PLANNING CONSULTATION RESPONSE

Application No	2026/0247
Address	177 High Street, Royston, Barnsley, S71 4RR
Date of Consultation Reply	23/06/2026
Name	Cllr Stefan McCrum

Front Elevation House Type 1 View From High Street

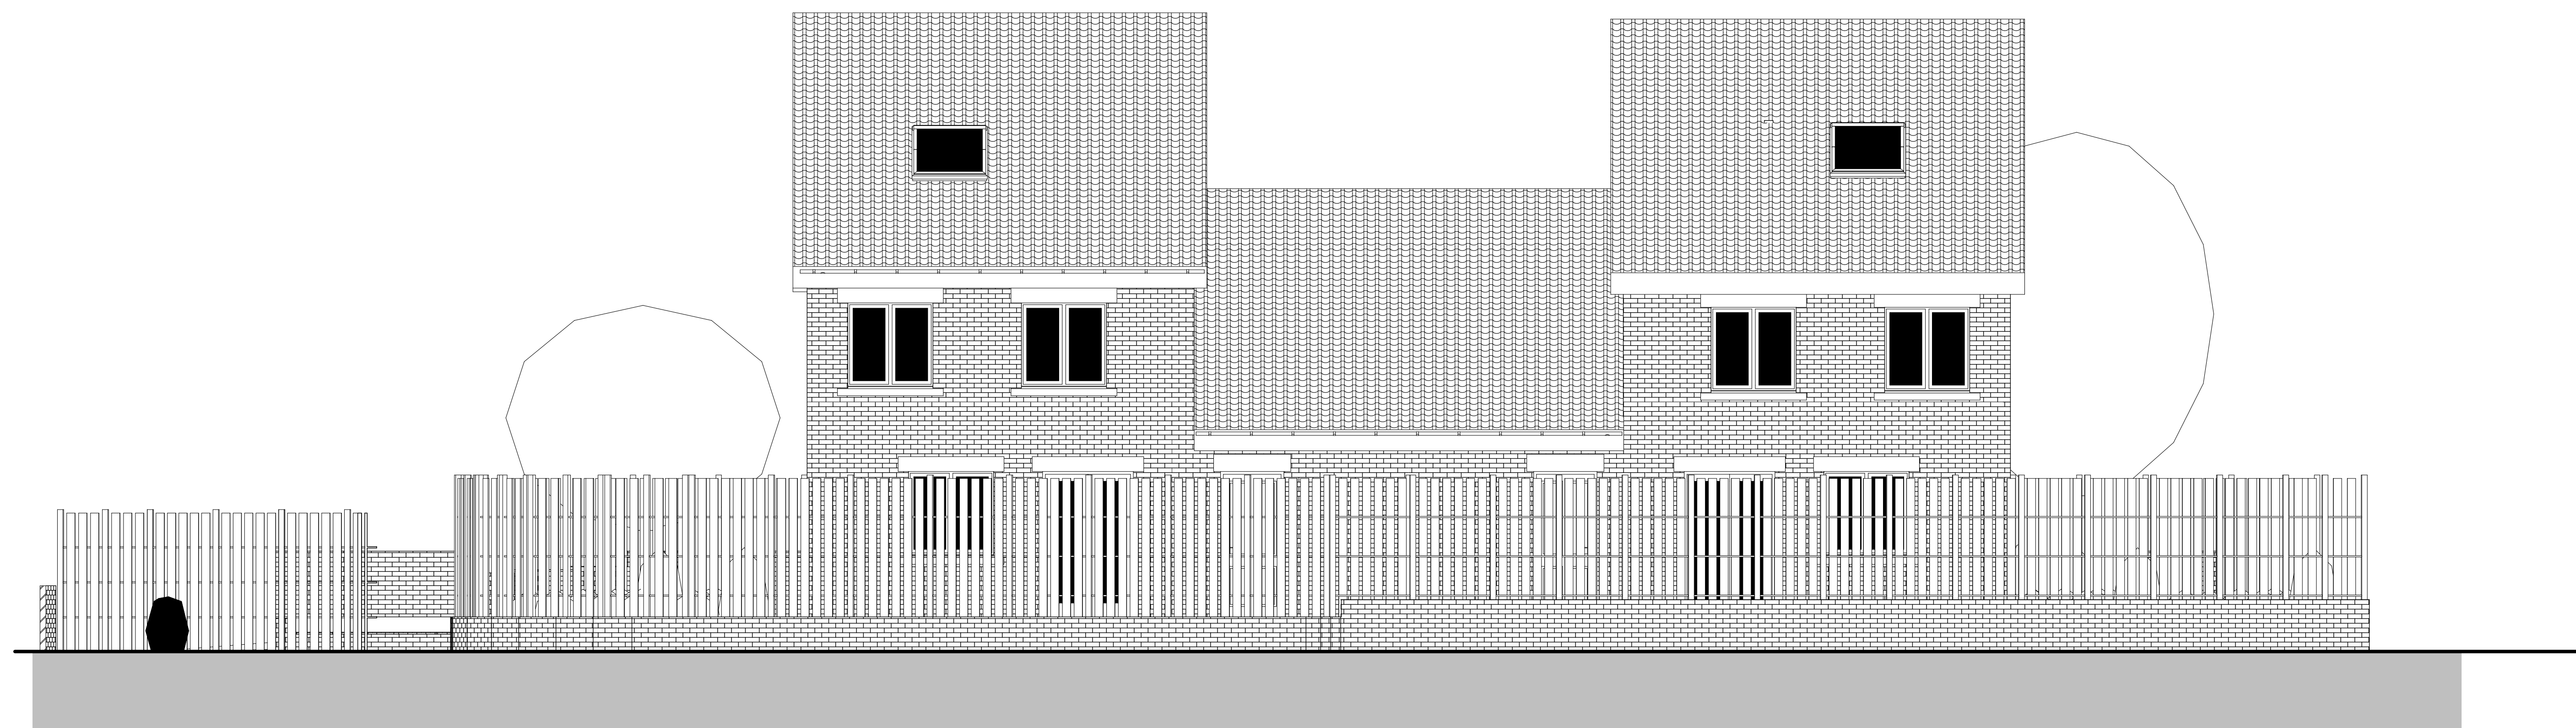
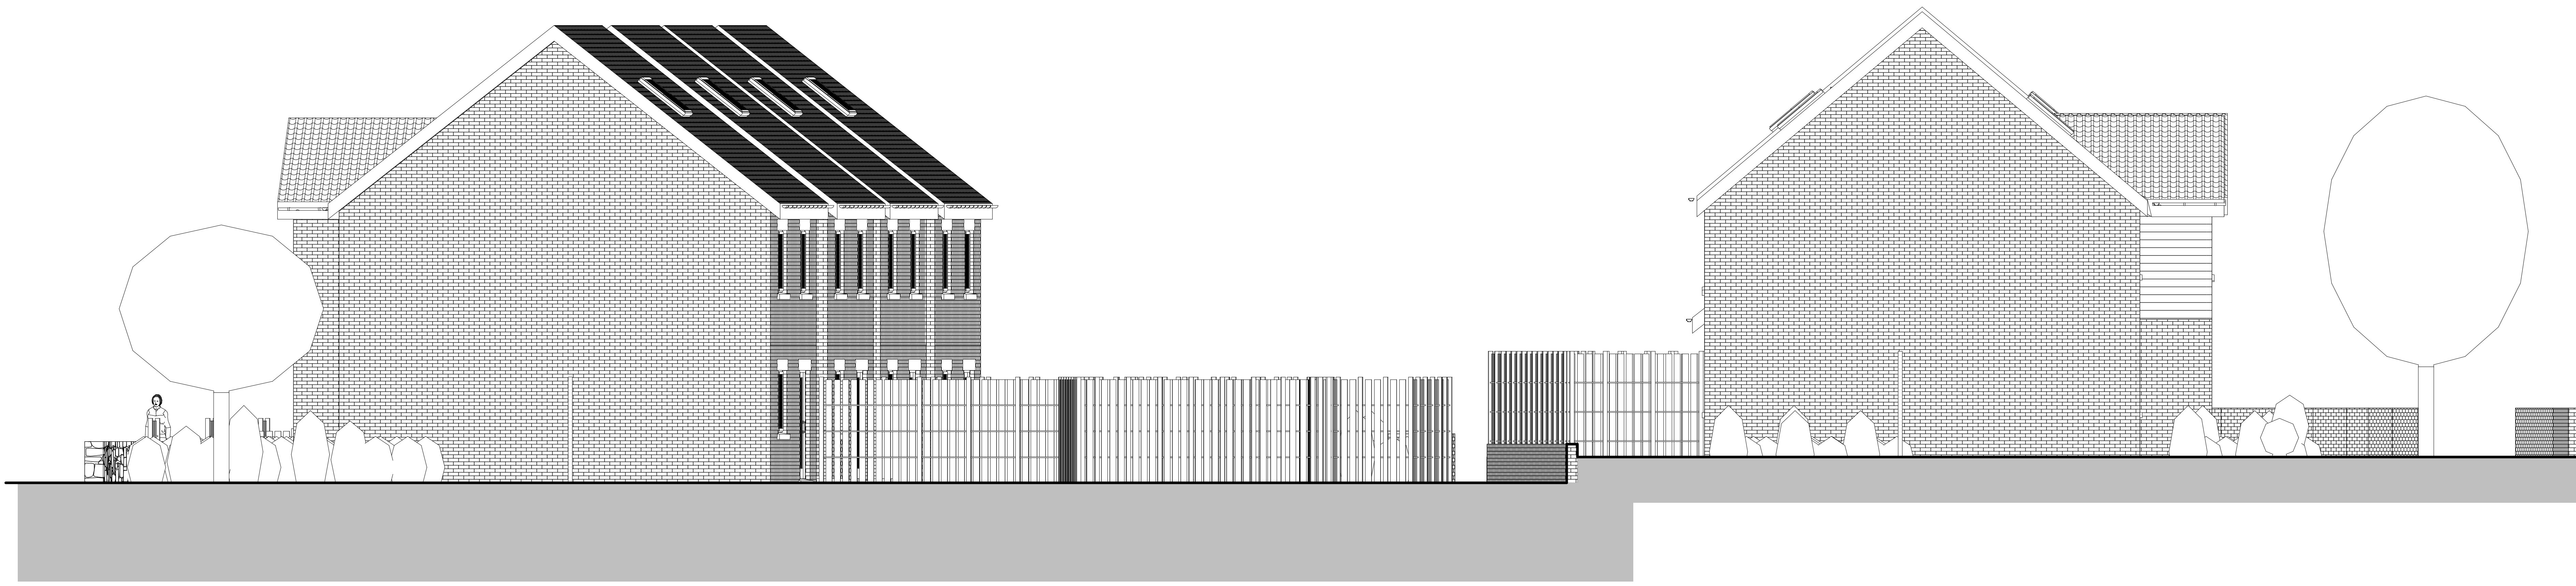
Furthermore, placing tall three-storey houses on a street almost entirely characterised by single-storey bungalows is completely out of character with the area.

Back Lane w

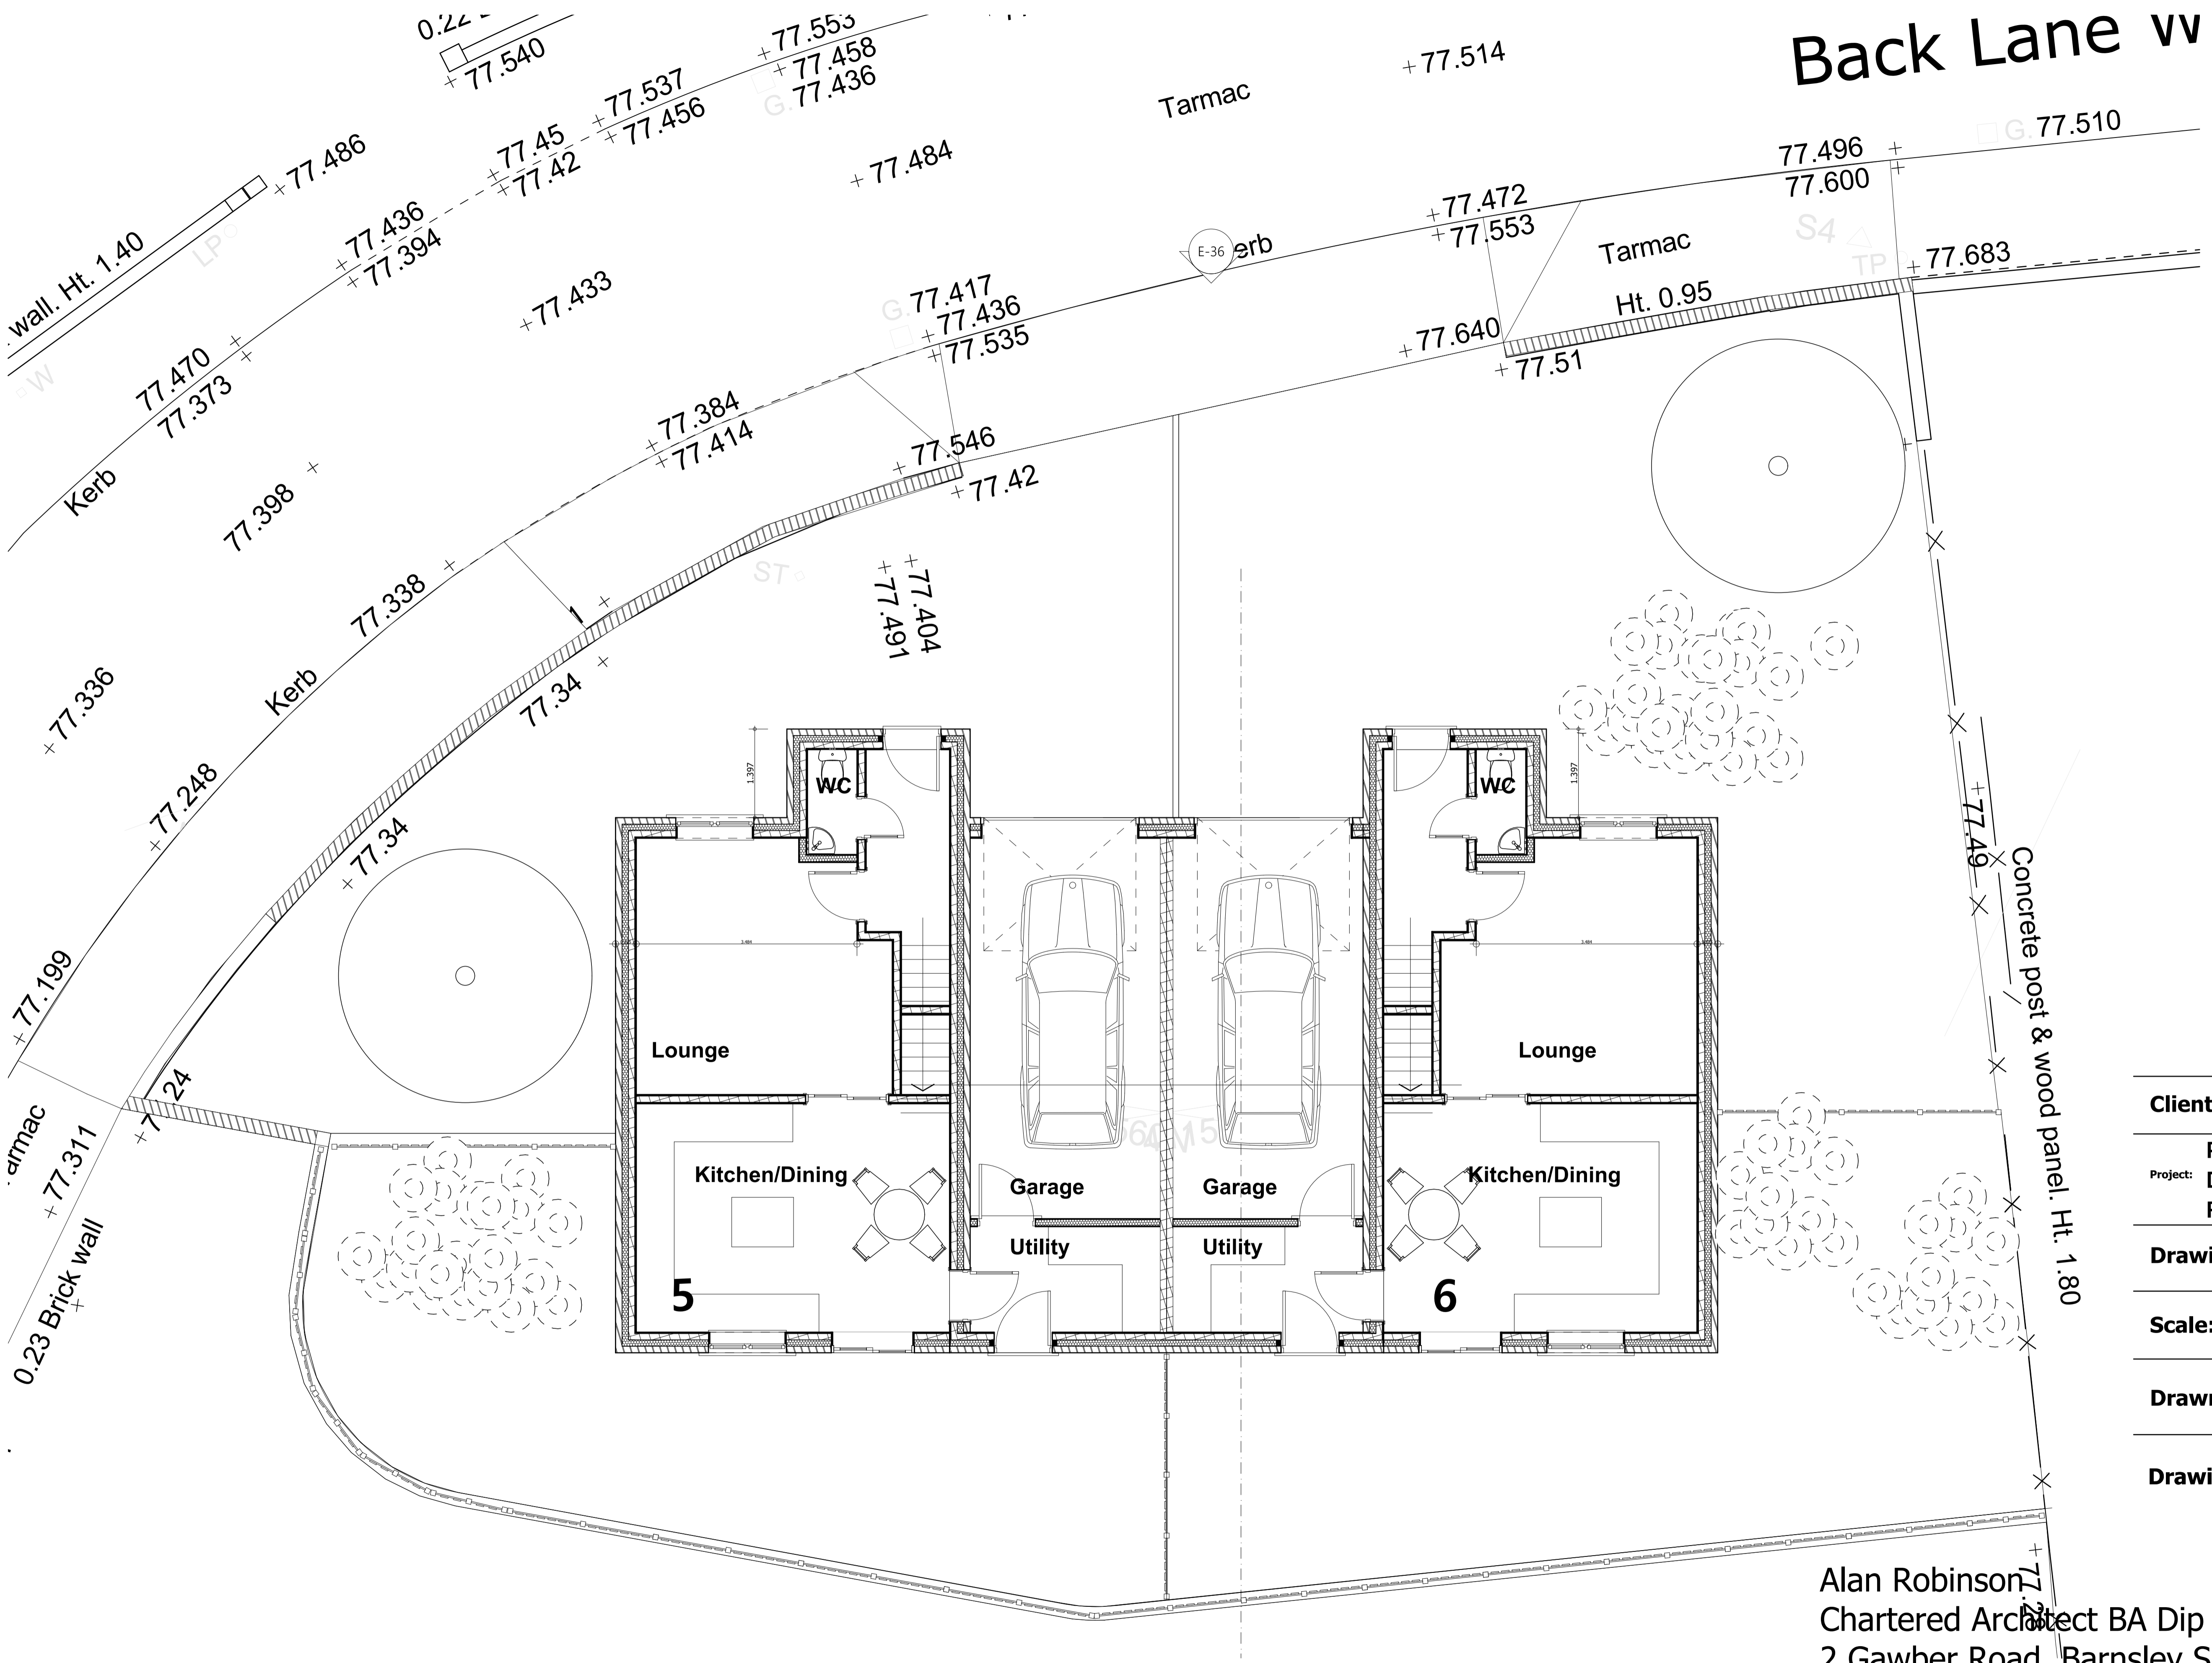
This proposal represents severe overdevelopment that will directly harm the local community. The site plans introduce two new site entrances directly onto Back Lane West.

This road is already in a state of chronic parking stress, serving as the primary parking area for residents of the High Street terrace houses who have no off-street options.

Adding 6 large, three-storey family homes with multiple vehicles, alongside two new access points, will destroy vital parking spaces, compromise highway safety, and cause traffic gridlock.
